Ribble Valley Borough Council
Development Control

Application no: 3/2019/0999
Address: Henthorn Road Clitheroe
Proposal: Outline Application for up to 160 Residential Units

Project		Title	ashleyhelme associates 76 washway road, sale, manchester, m33 7re e: aha@ashleyhelme.co.uk t: 0161 972 0552 f: 0161 972 0553	Drg No	Rev
HENTHORN ROAD, CLITHEROE				1677/01	A
Client		PROPOSED ACCESS ARRANGEMENTS	Date	Scale	
GLADMAN DEVELOPMENTS			AUGUST 2019	1:500@A2

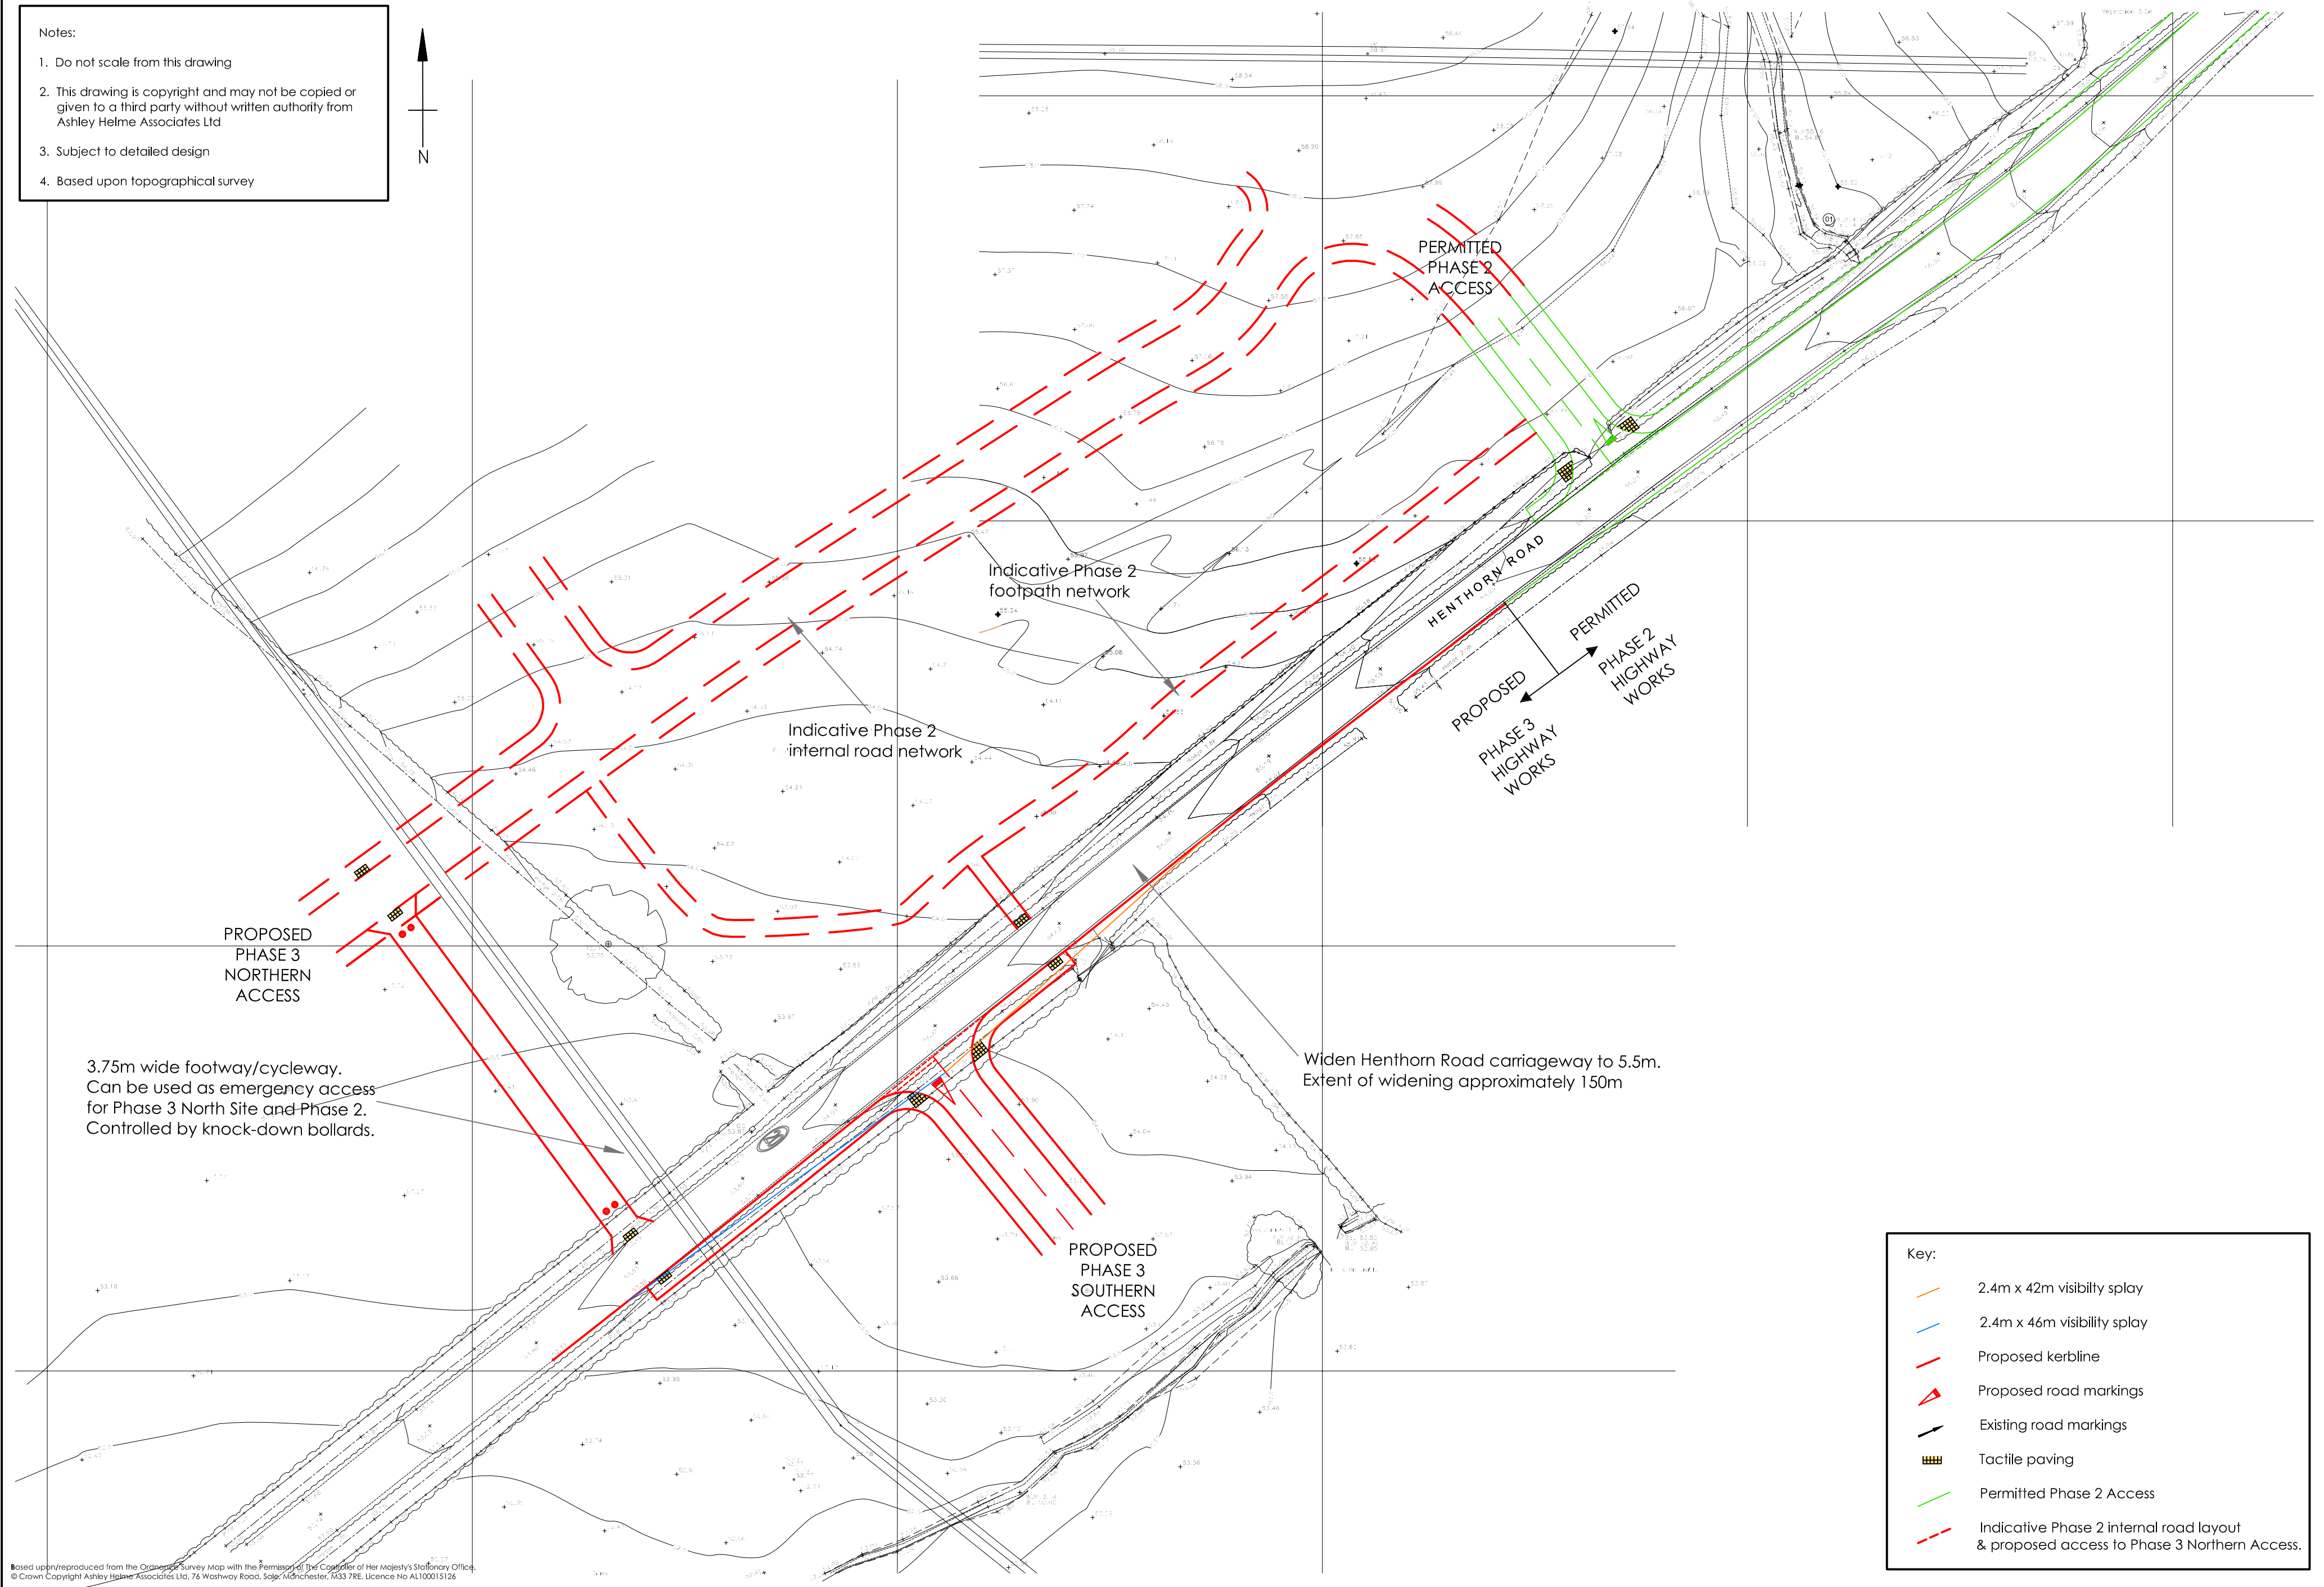
Vehicular access to Phase 2 (to the north of Henthorn Road) will be gained via the adjacent Phase 1 development whilst access to Phase 3 (to the south) will be via a new access point. Vehicle speed surveys have been carried out and the phase 3 access will have visibility splays appropriate to the prevailing 85thile speeds on Henthorn Road which in this instance will be 2.4m x 42m to the left on exit and 46m to the right. I am therefore satisfied that the appropriate local access visibility requirements can be achieved.

In addition to the vehicular access points, the applicant also proposes a 3.75m wide pedestrian / cycle link on to Henthorn Road to the south westerly of the corner of the site with the option of this being available as a secondary emergency access route and a separate pedestrian access point further east along the site frontage. Although the internal layout of the development will be subject to reserved matters, it is noted that within the submitted documents (Dwg 1677/01) that it is intended that the latter pedestrian access will connect to an internal footway at the expense of providing a footway directly adjacent to Henthorn Road. This layout is not supported by the highway authority.

Other than facilities at the vehicular access there are no separate pedestrian or cycle facilities to Phase 3

With the exception of the proposed vehicular access points and the drawing referred to in para 2.0 above (Dwg 1677/01) there is no information provided in respect of the internal layout of the proposed development. It is

- Localised widening of Henthorn Road to a minimum of 5.5m from Blakewater Road to the western boundary of the development frontage onto Henthorn Road.
- Provision of a 2m footway along the northern side of Henthorn Road for the full extent of the Phase 2 site frontage onto Henthorn Road. To its junction with Blakewater Road Provision of a 2m footway along the southern side of Henthorn Road from the proposed vehicular access to its junction with Blakewater Road
